BLACK SLUICE INTERNAL DRAINAGE BOARD

Our Ref: SMH/SH/P.H04/1424/00

Date: 30 January 2001

Planning Application No H04/1424/00 – Proposed Change of Use from Garden to Building Plot at Red Gables, Town Dam Lane for Mr J E Turnell

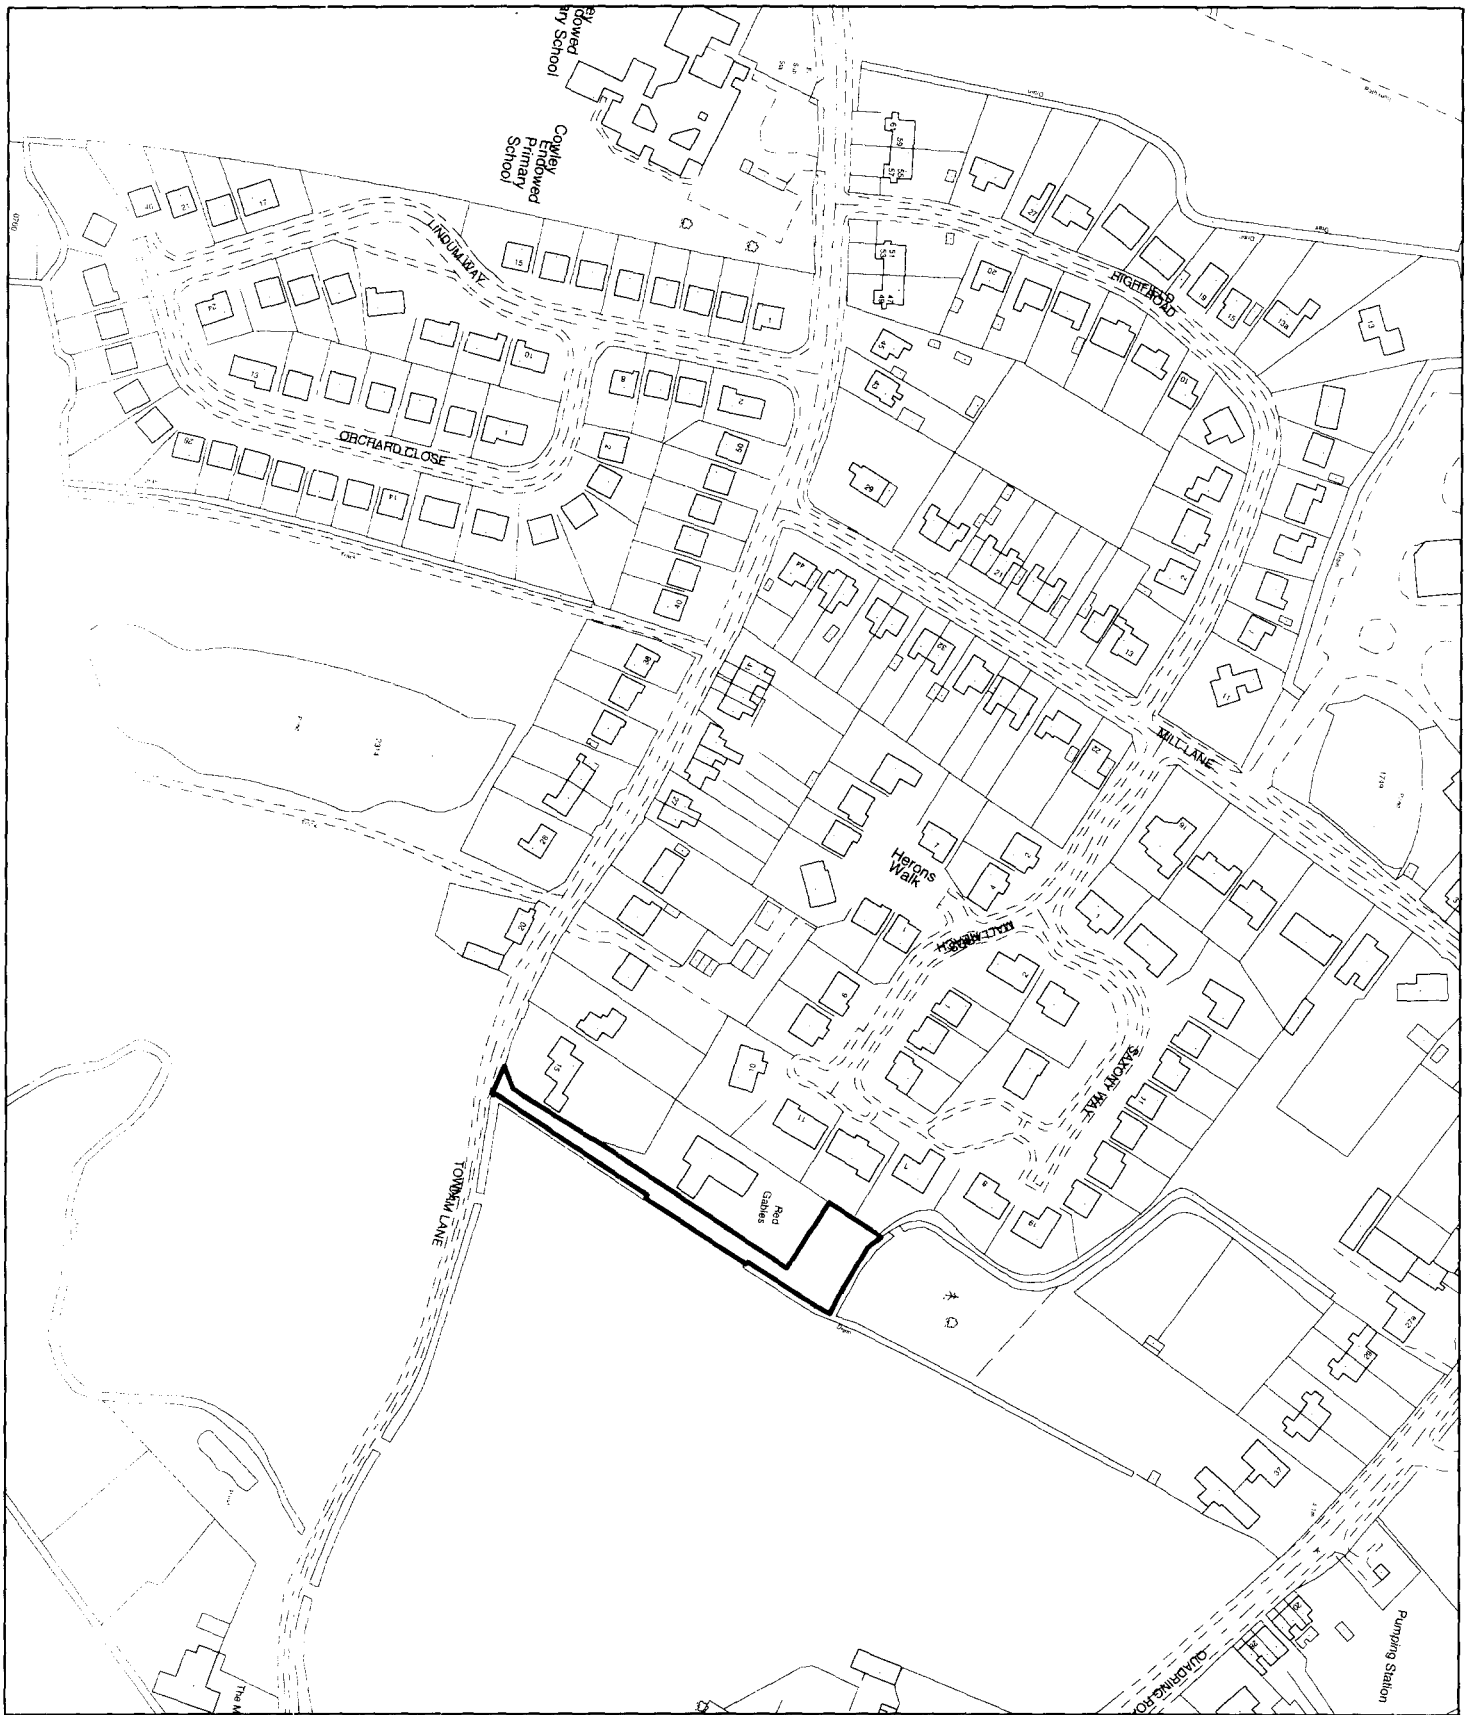
It is noted that the applicant proposes to discharge the surface water into soakaways. All of the surface water from the adjoining development is drained to a surface water drainage system. Particular attention should be taken when carrying out percolation tests to ensure that soakaways will operate satisfactorily and not cause waterlogging on the proposed and adjoining plots.
